Application for a non-material amendment following a grant of planning permission.

Erection of a two storey rear extension, 2nd storey enlargement of side dormer and conversion of garage to study including demolition of existing conservatory

Reference number:	EP/166/18/HH
Date of decision	01/02/2019

Alteration of rear parapet roof profile and addition of first floor window to southern elevation

Proposed Elevations
1:100

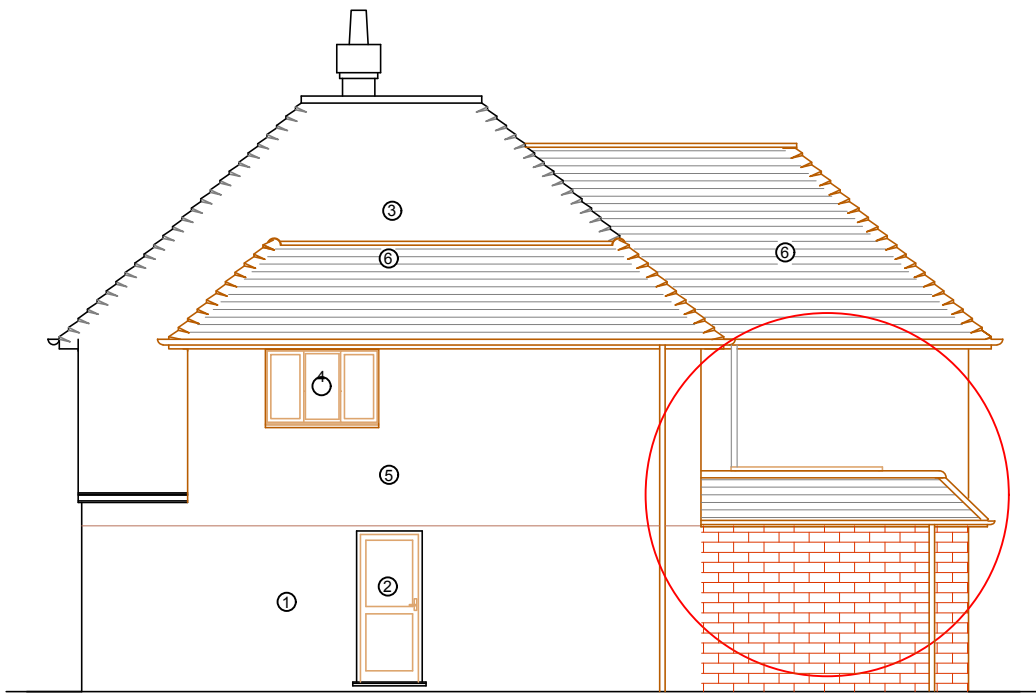
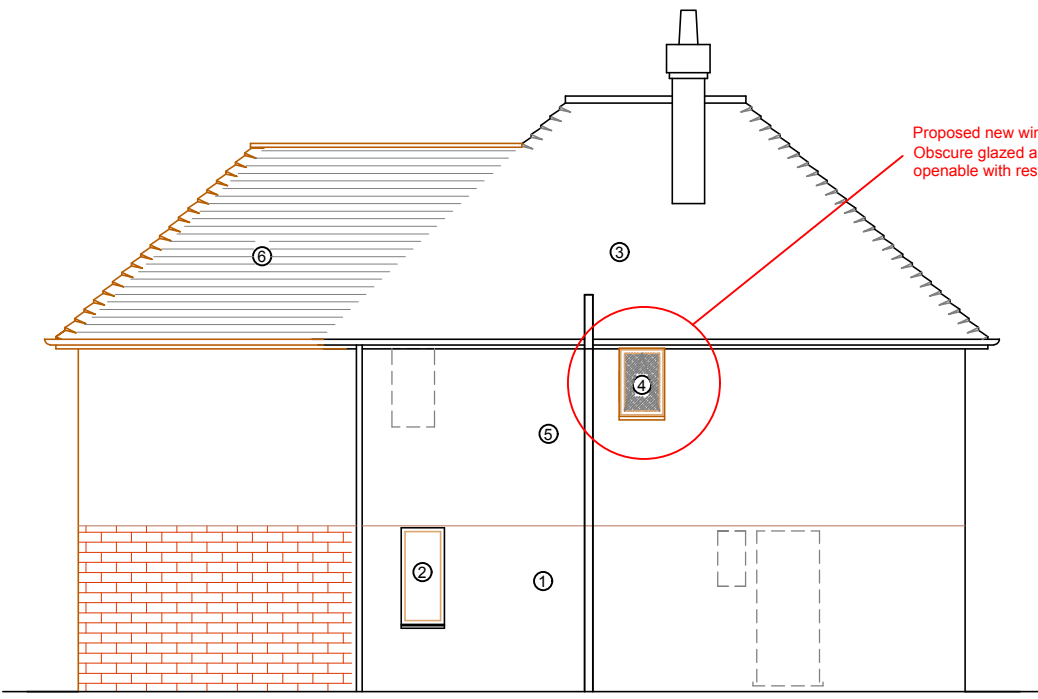
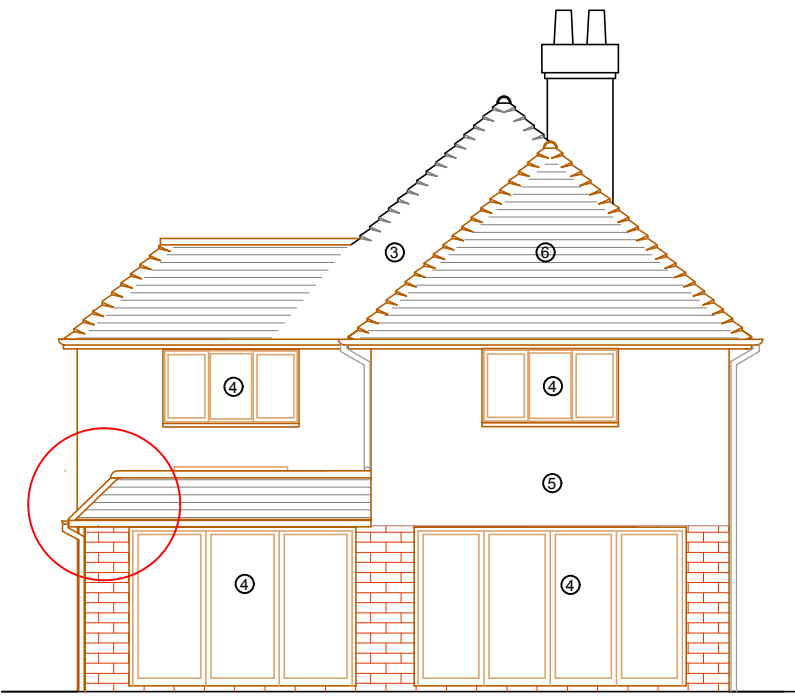
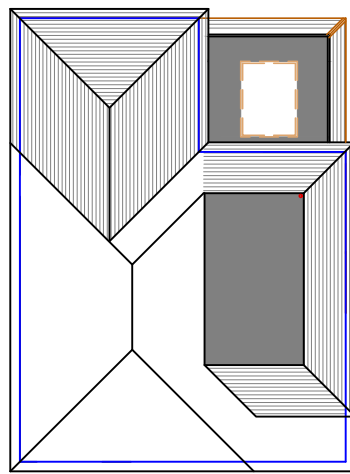
Change of roof to be more aesthetically pleasing. New window to ensuite bathroom to provide natural light and ventilation.
